From: Laura Gibbons
Sent: 05 November 2018 16:14
To: Planning.Responses
Cc: Anita Gardner
Subject: RE: Planning Consultation on M/132/18/DOC

APPLICATION NO: M/132/18/DOC

Site Address: Middleton House Yapton Road Middleton PO22 6DU

Description of Works: Application to discharge condition 6 of M/39/17/HH relating to drainage - SW Attenuation tank with connect to onsite CD (option 3)

PROJECT	MIDDLETON HOUSE YAPTON ROAD MIDDLETON PO22 6DU
DRAWING	PROPOSED DRAFT SW DRAINAGE LAYOUT OPTION 3 - ATTENUATION TANK - CONNECTED TO CS
SCALE	FC2780/2.3
DATE	1:100
DATE	OCT 18
INITIAL	MH
CHKD	-
REV	-

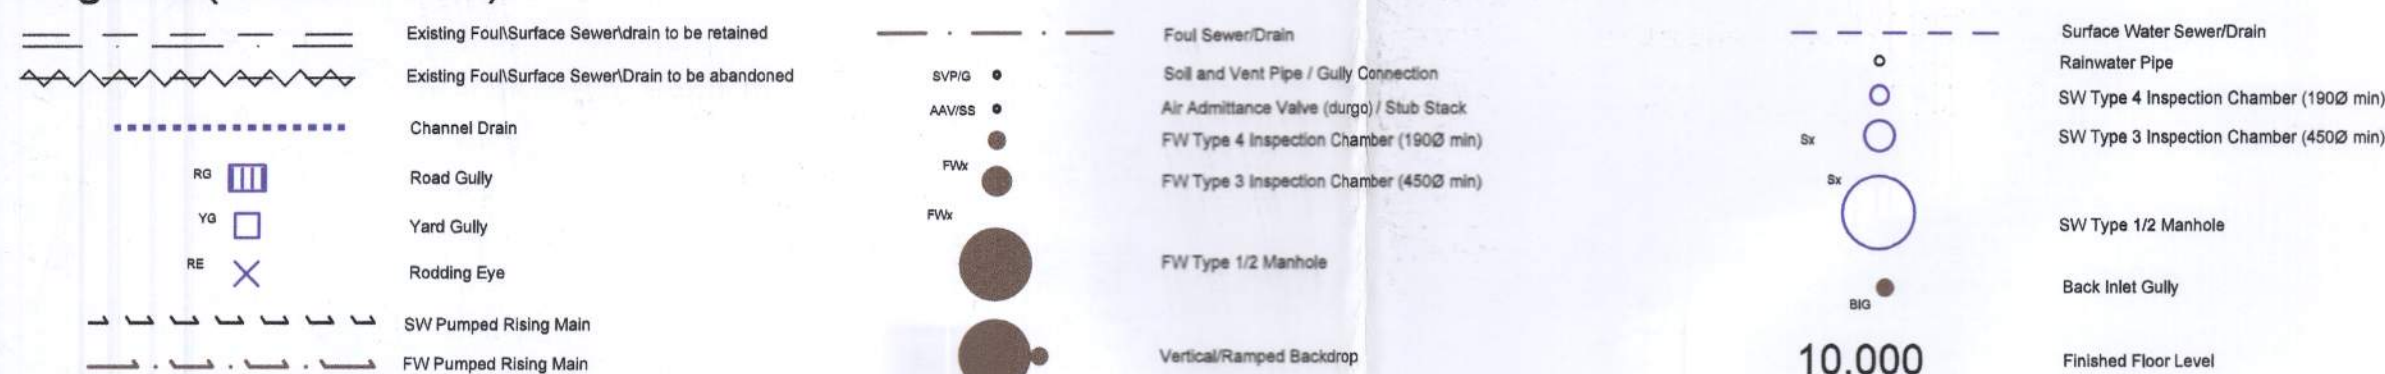
I recommend the partial discharge of the condition. This is based on the fact that there is sufficient room on site for the three options provided.

The condition will not be able to be fully discharged, and occupation is not permitted until it is. I will require the groundwater monitoring and infiltration testing to be completed not before December and the options to be reviewed based on this. Option 1 or 2 should be pursued first. I expect the design to be revised based on the infiltration test results and will need full construction details to be submitted at this point to fully discharge the condition. Construction of the surface water drainage will then need to be completed in accordance with the approved plans.
